CITY OF MERCER ISLAND

REVISION/DEFERRED SUBMITTAL FORM

Site Address 7450 N Mercer Way

Permit Number 1904-048

A-1.3

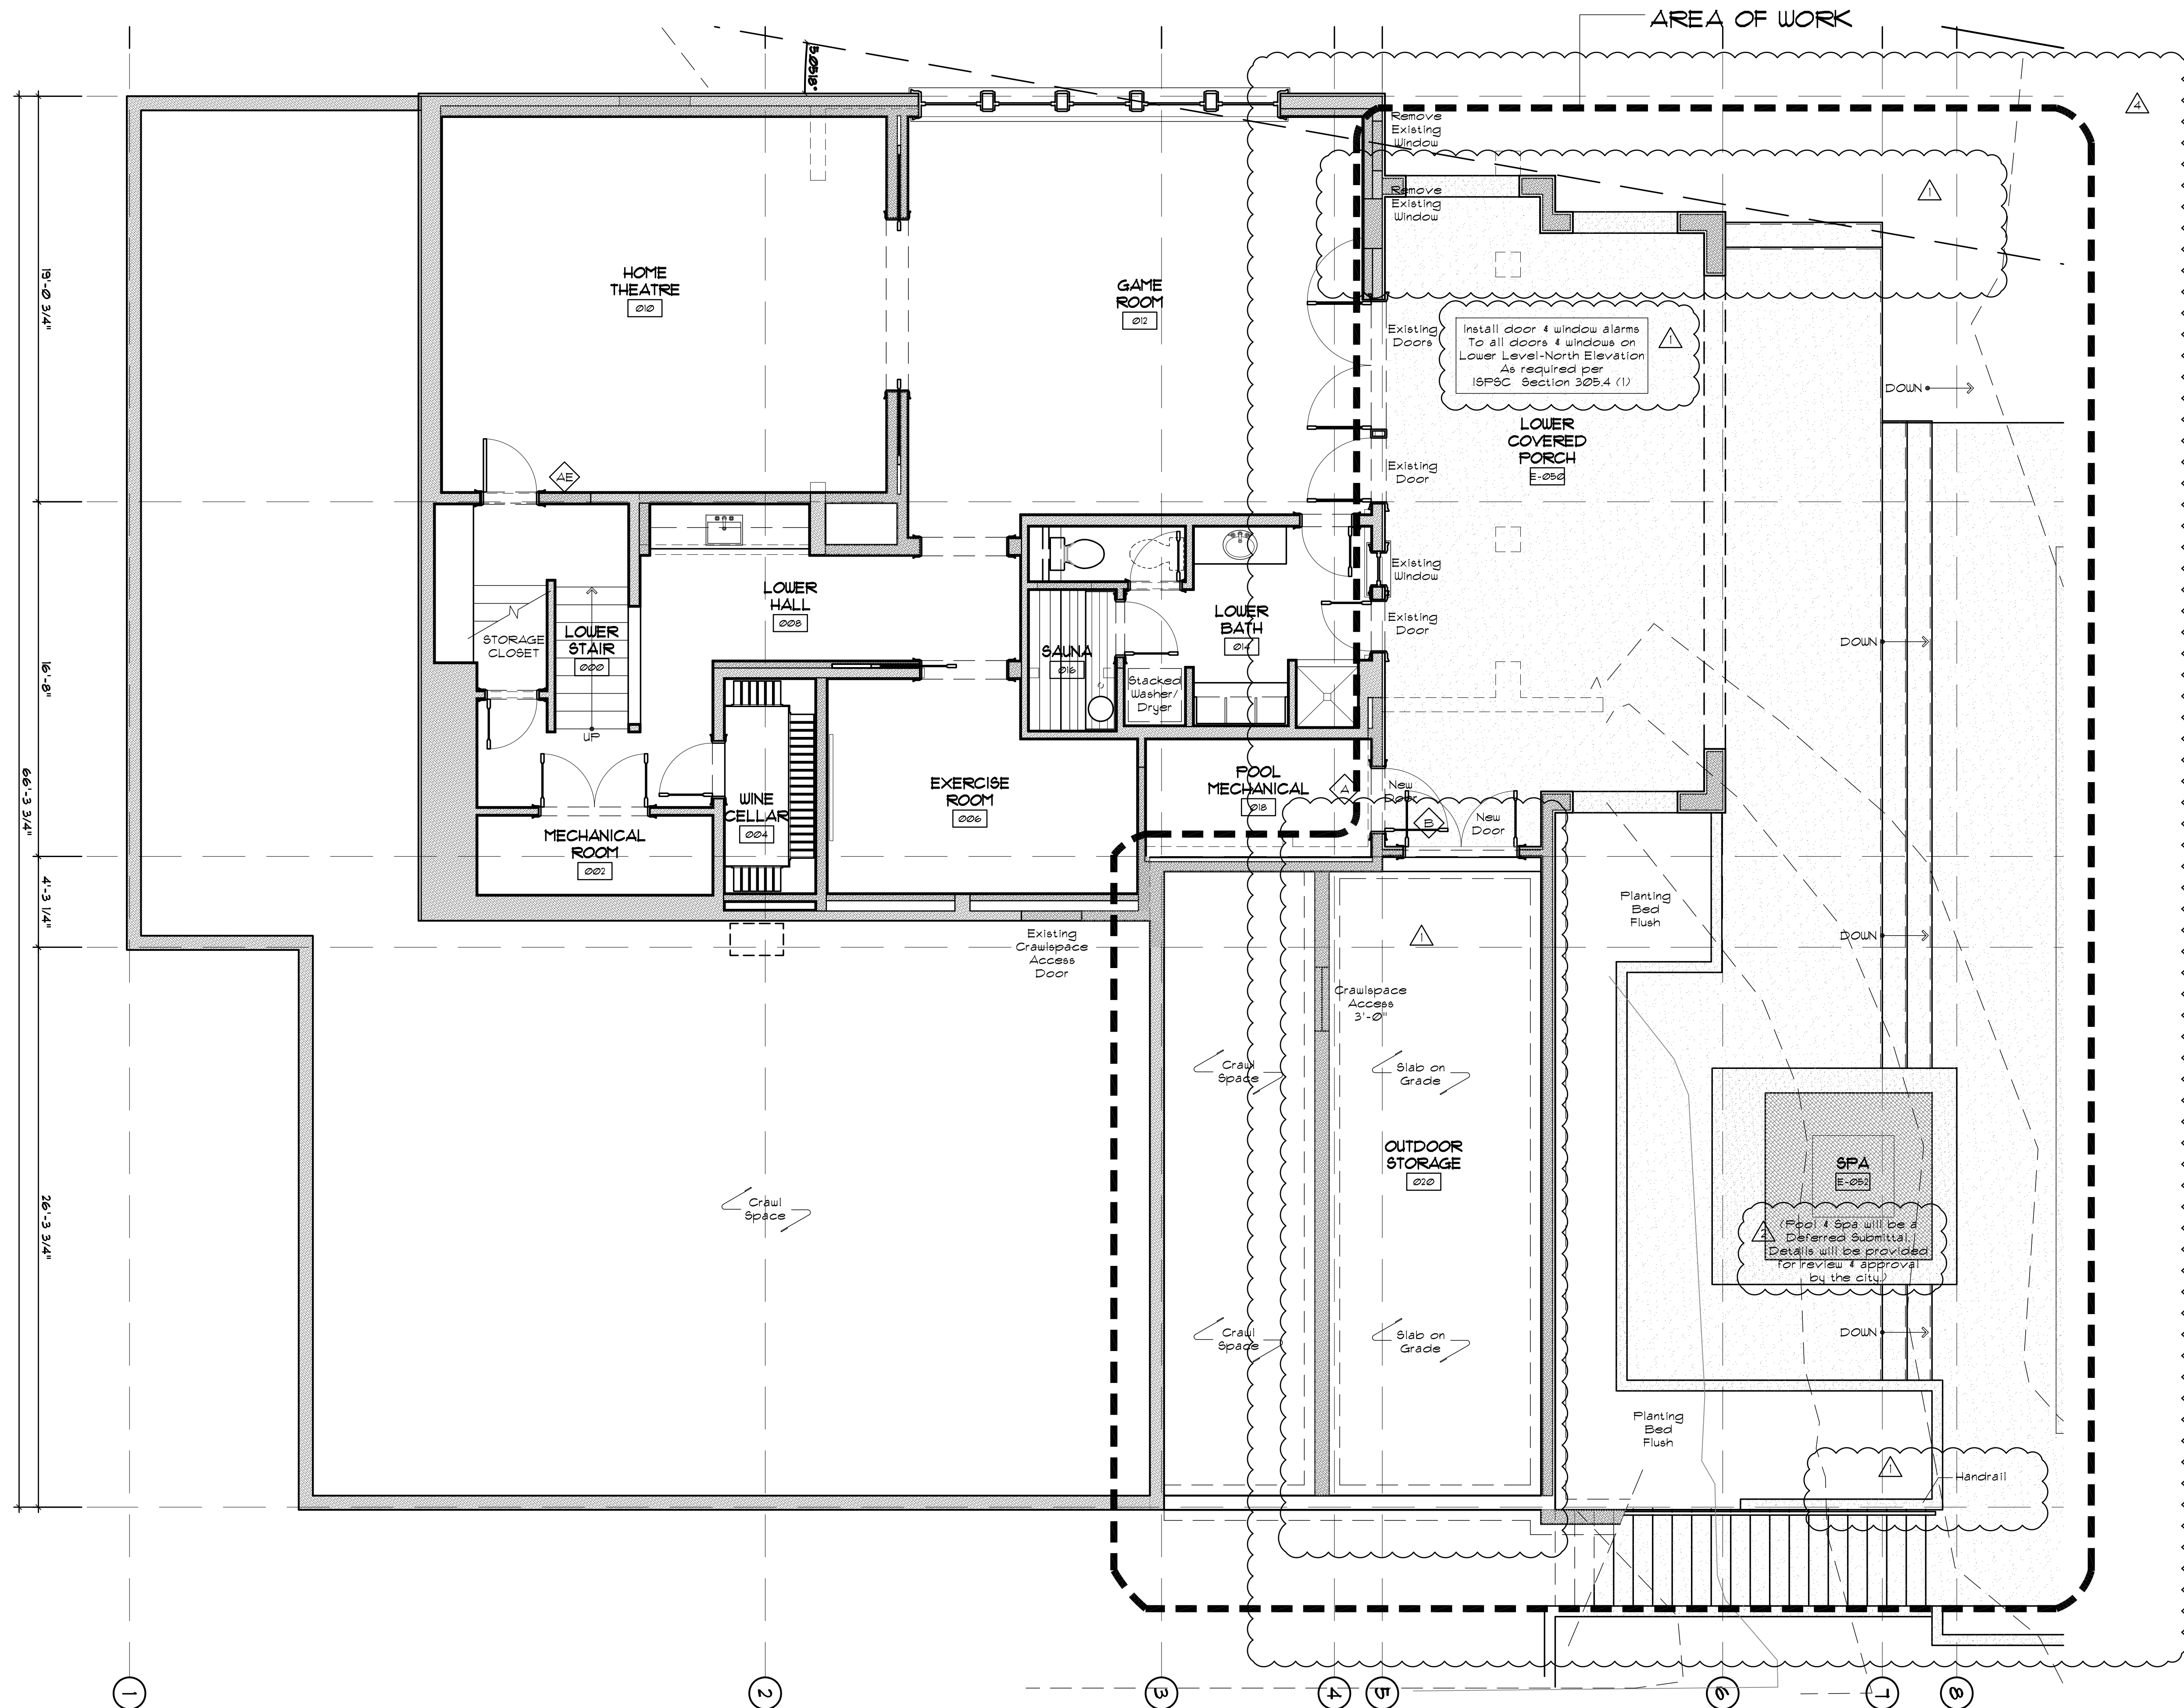
Sheet #	<u>A-1.3</u>	Updated lot & hardscape coverage. Both diagrams & calcs updated.
Sheet #	<u>A-2.1</u>	Lower Covered Porch revised. Pool stair, Pool & Terrace reconfigured.

A-2.2

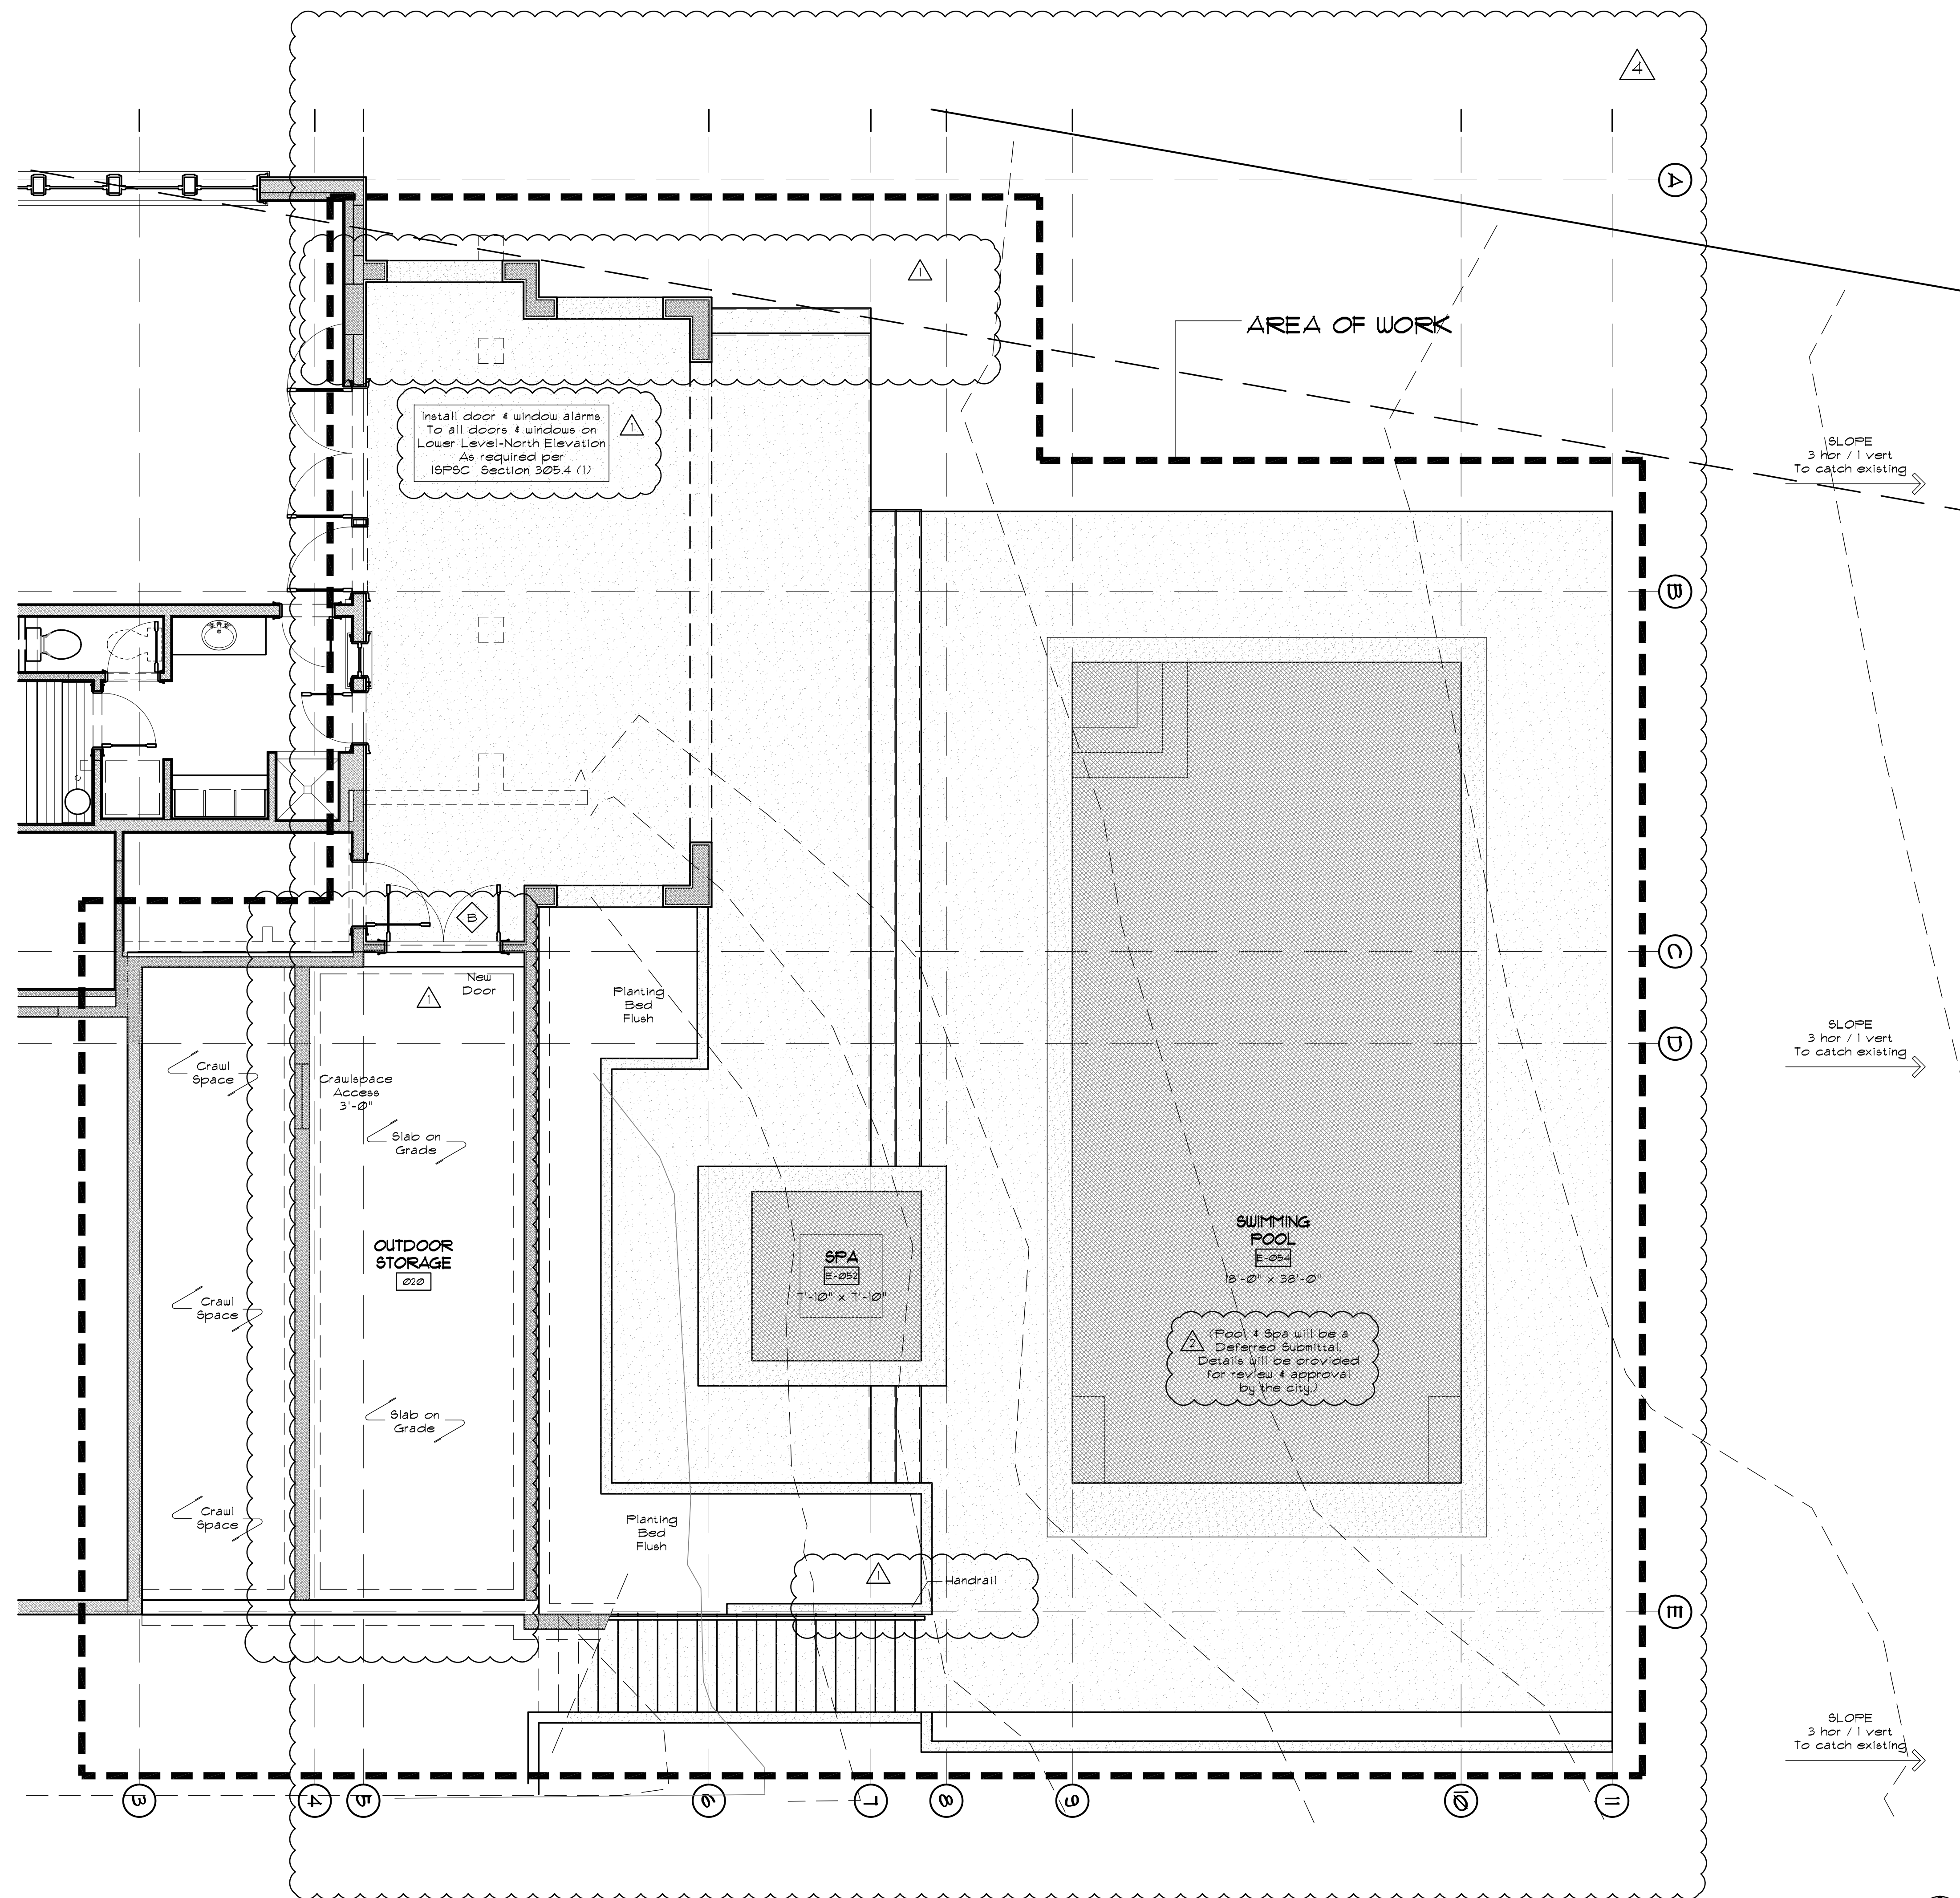
Sheet #	<u>A-2.2</u>	Main Covered Porch revised. Pool stair reconfigured.
Sheet #	<u>A-2.5</u>	Lower Covered Porch revised. Pool stair, Pool & Terrace reconfigured.

B SYMBOL B LOCATION Outdoor Storage DOOR DIAGRAM Scale: 1/2" = 1'-0"

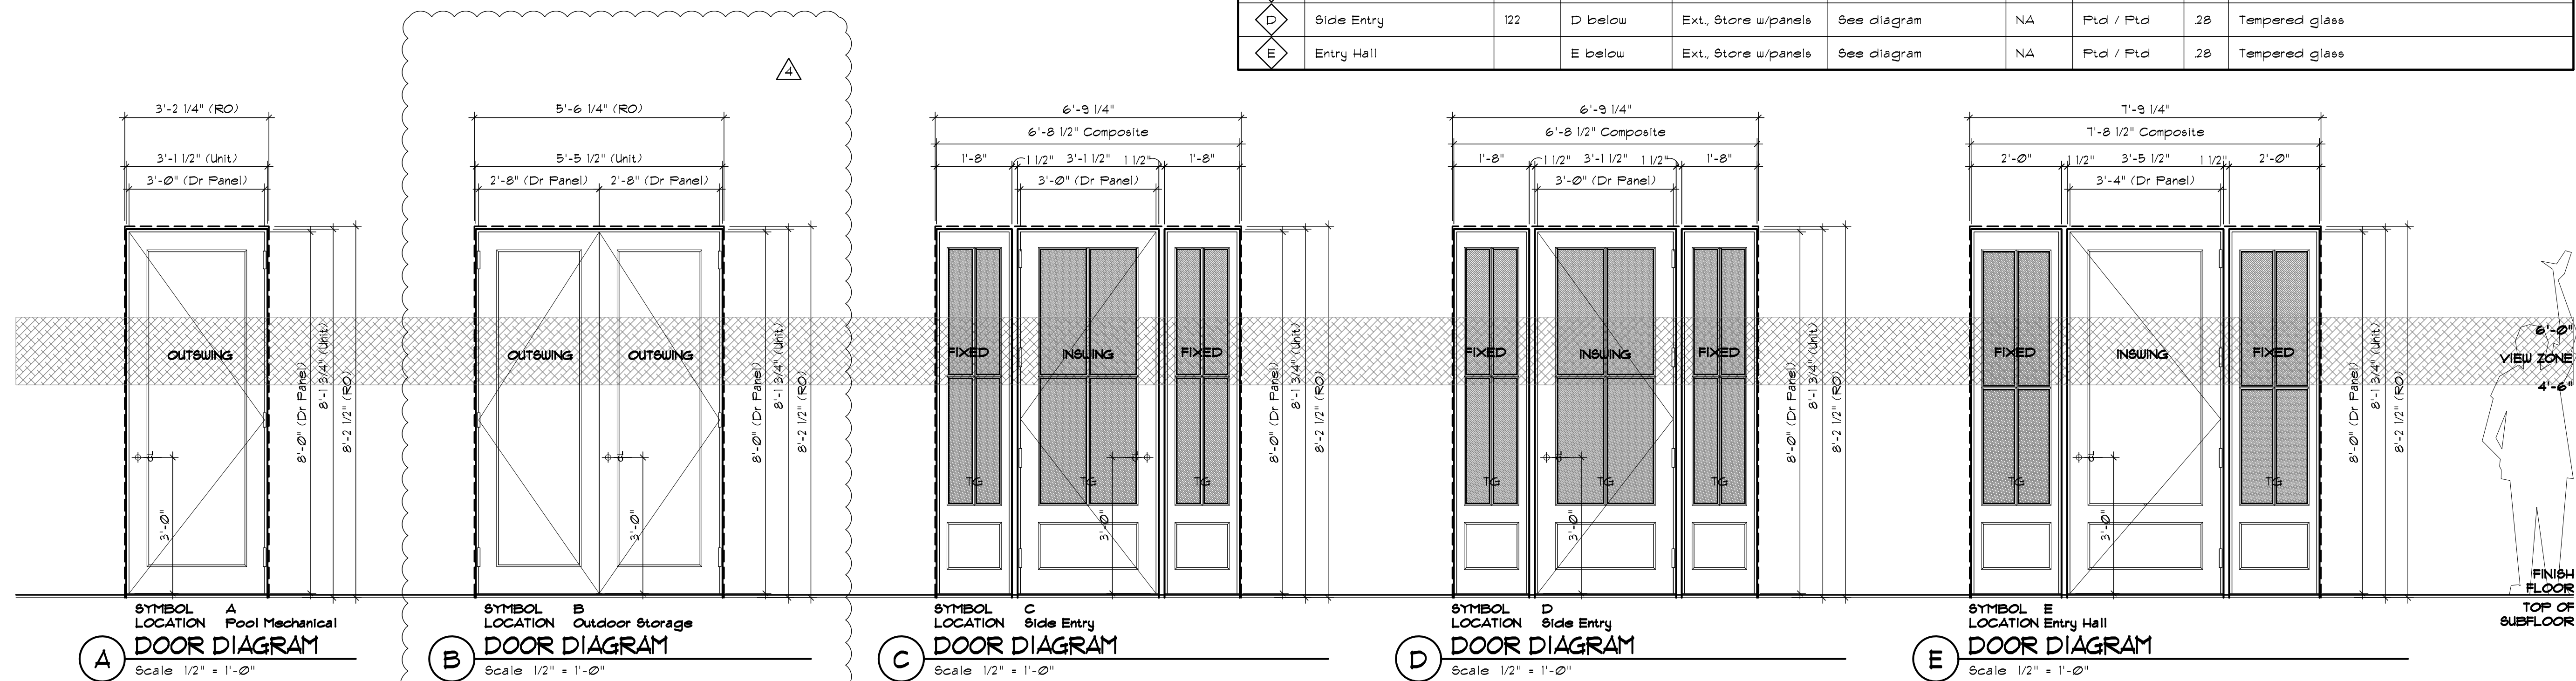
Sheet #	<u>A-5.1</u>	Updated Door B
Sheet #	<u>S 1.1</u>	Concrete Note #19 revised.
Sheet #	<u>S 2.1</u>	Lower Covered Porch revised (see SSF memo for details)

SITE IMPROVEMENT PLAN
LBH RESIDENCE
7450 NORTH MERCER WAY
SEAN KELL
14033 SE 92ND STREET
NEWCASTLE, WA 98059

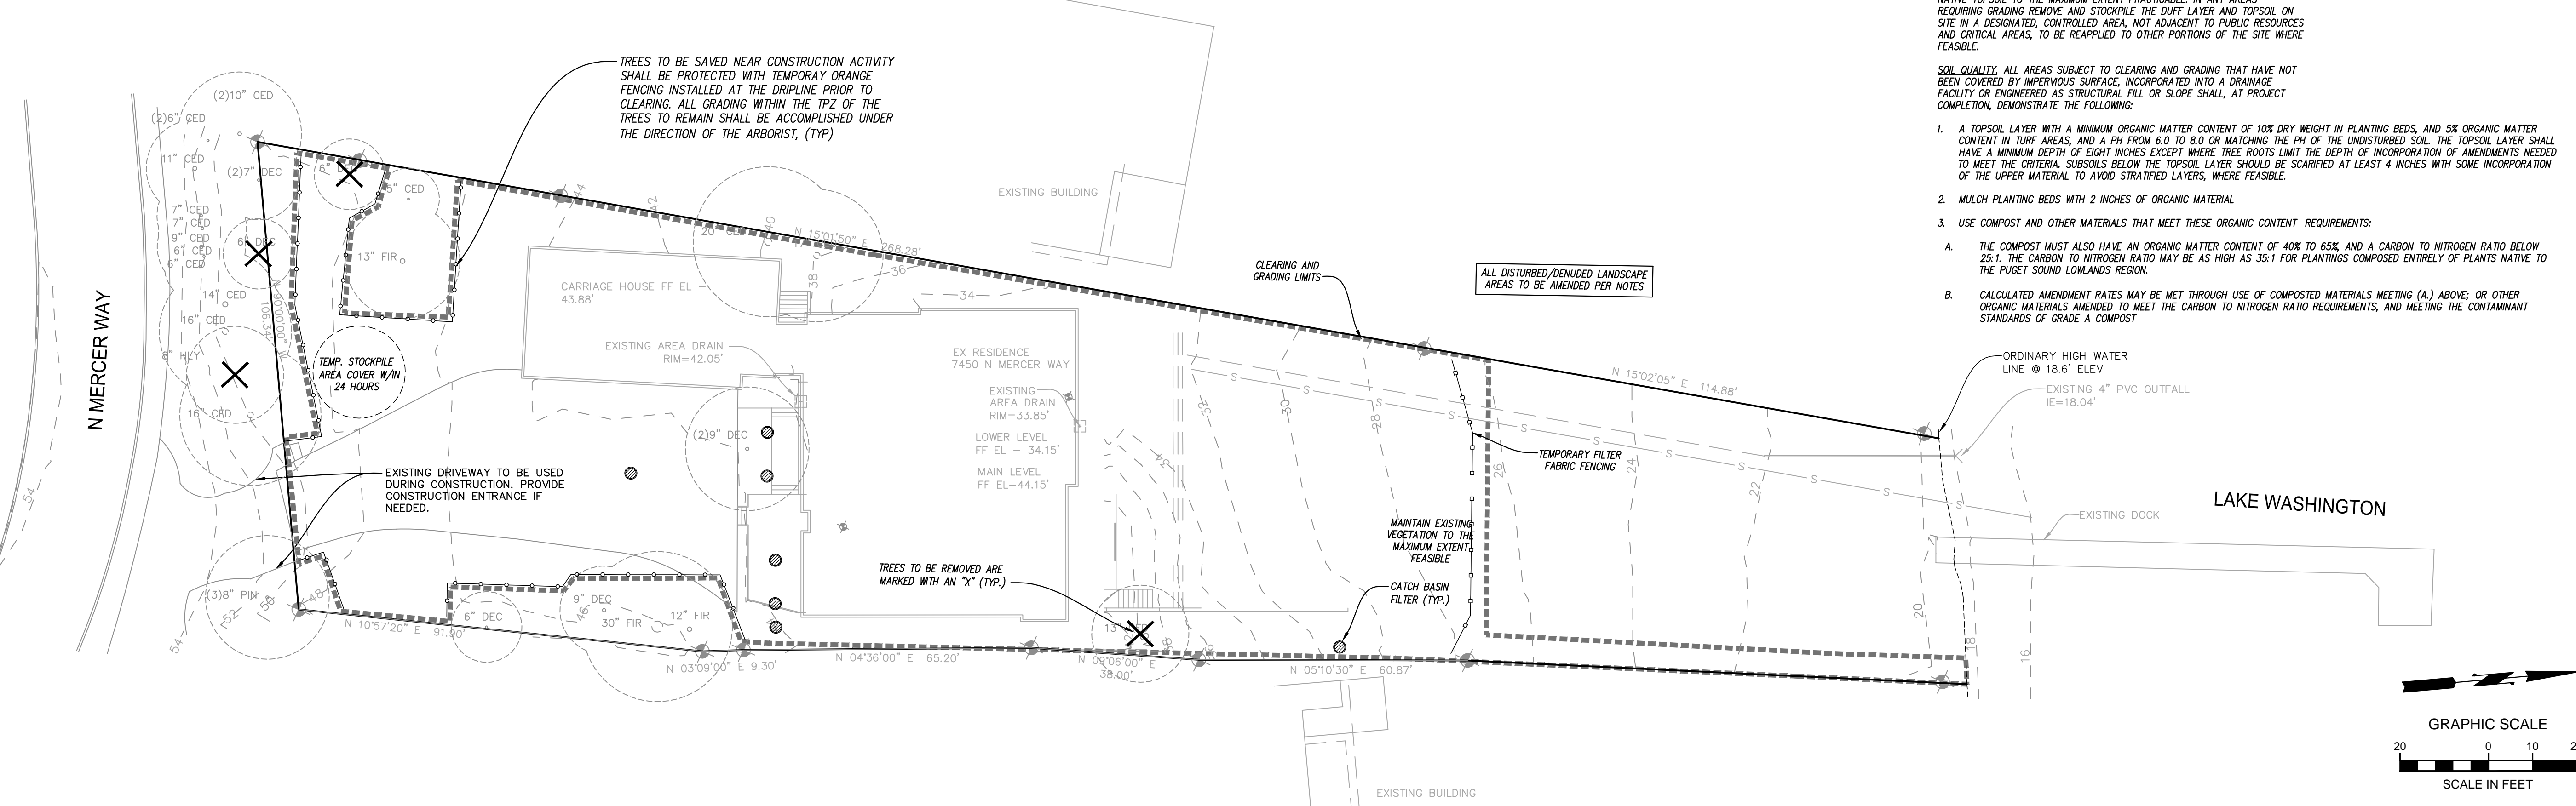
Sheet #	C-1of2	Civil Site Improvement Plan revised to match architectural site plan changes.
Sheet #	C-2of2	Civil TESC & SWPP Plan revised to match architectural site plan changes.
